# City of Albuquerque Stormwater Construction Site Inspection Report

General Information					
ESC File No.	A11E018A		Project Name:	IHOP/Paris Baguette	
NPDES Id. No.	NMR1006PM		Location:	10850 Unser Blvd NW	
10/2/2024	Owner		Contractor		
Operator	Uncer Property, LLC		Confederated Builders		
Contact name & title	Mohamad Touffaha				
e-mail	<a href="mailto:mtouffaha@gmail.com">mtouffaha@gmail.com</a>				
Contact Phone #	316-308-5507				
COA Inspector	Chancellor English		Start/End Time:	11:45am	
Construction Phase:	scrubbed				
Type of Inspection:	Regular	Storm Event	Post Storm Event >0.25"	311/Complaint	Follow Up
Weather at time of inspection?	Clear		Temperature: ~	85	
Estimated date of last storm 0.25" or greater	8/31/2024

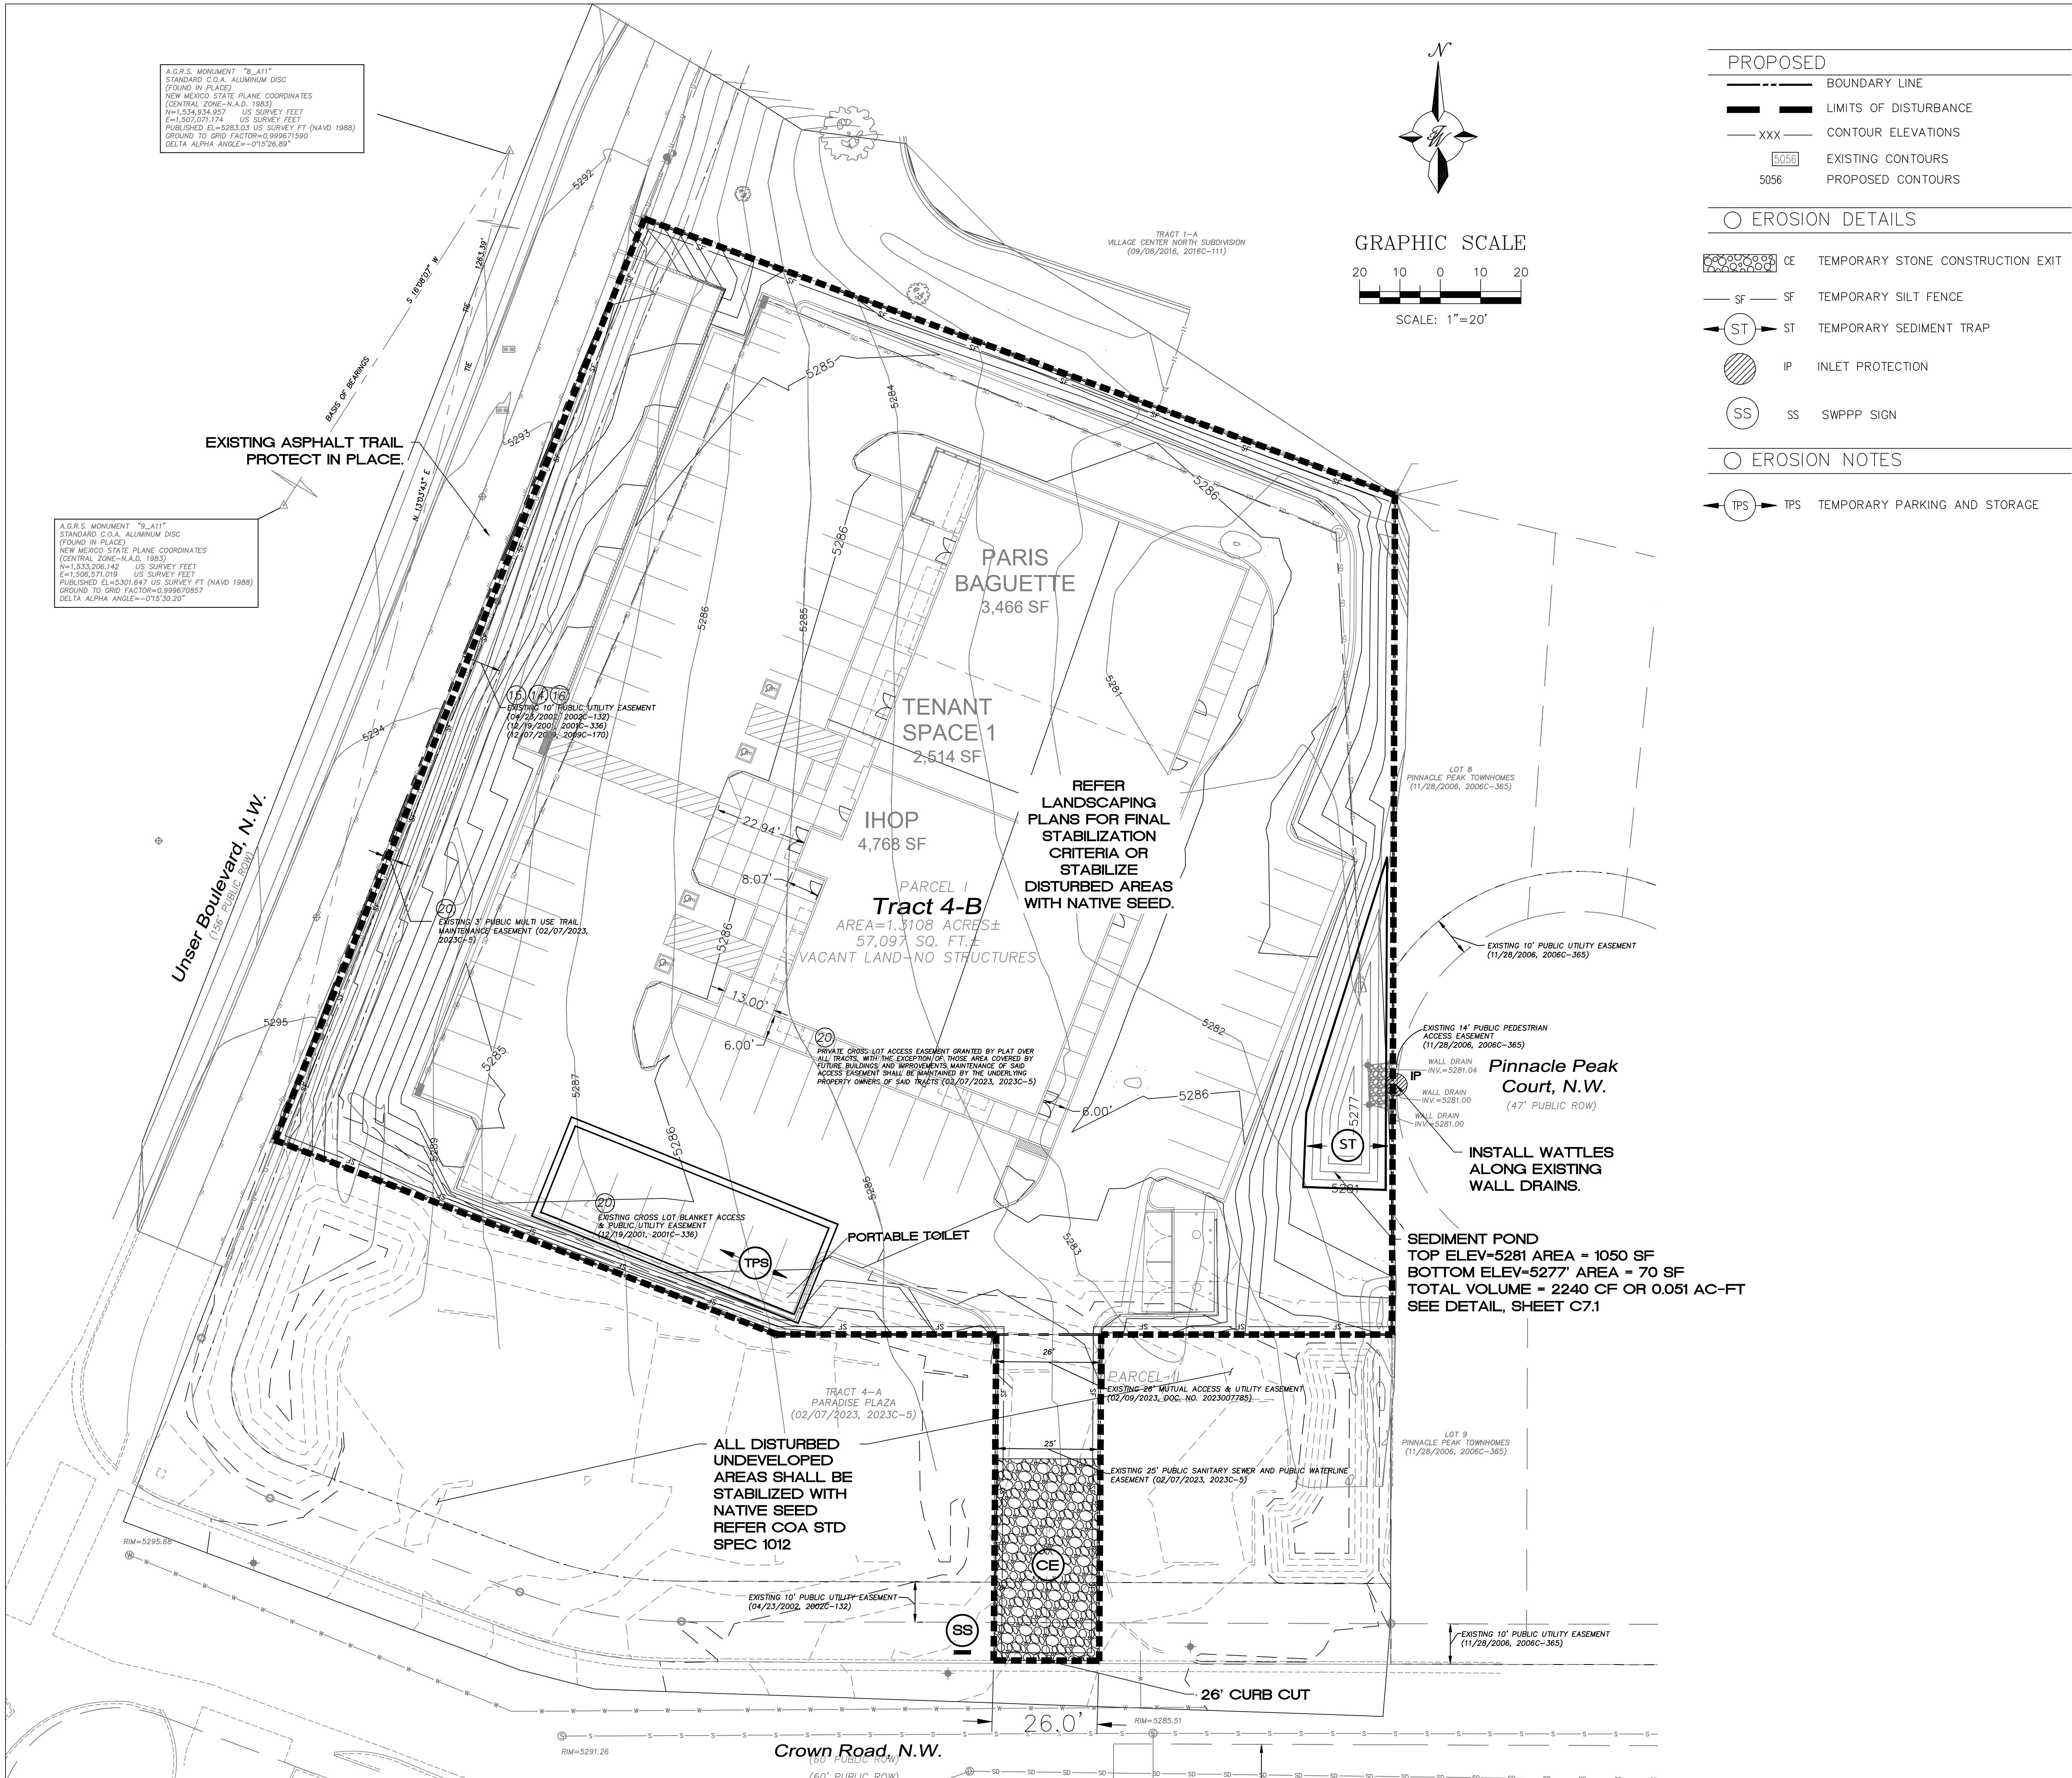
Item Number	Deficiency/ Corrective Action				
1	SWPPP - The self-inspection report was missing signatures in violation of CGP Part 4.7.2. The stormwater team was not properly identified in violation of CGP Part 7.2.2. Required mitigation: Each inspection report must be signed by the operator's signatory in accordance with CGP Appendix G, Part G.11. CGP 7.2.2 Stormwater Team. "Identify the personnel (by name and position) that you have made part of the stormwater team pursuant to Part 6.1, as well as their individual responsibilities, including which members are responsible for conducting inspections. Include verification that each member of the stormwater team has received the training required by Part 6.2. Include documentation that members of the stormwater team responsible for conducting inspections pursuant to Part 4 have received the training required by Part 6.3. If personnel on your team elect to complete the EPA inspector training program pursuant to Part 6.3a, you must include copies of the certificate showing that the relevant personnel have completed the training and passed the exam. If personnel on your team elect to complete a non-EPA inspector training program pursuant to Part 6.3b, you must include documentation showing that these persons have successfully completed the program and their certification or license is still current. You must also confirm that the non-EPA inspector training program satisfies the minimum elements for such programs in Part 6.3b." Include written documentation that the non-EPA inspector training program satisfies the minimum elements for such programs in Part 6.3b.
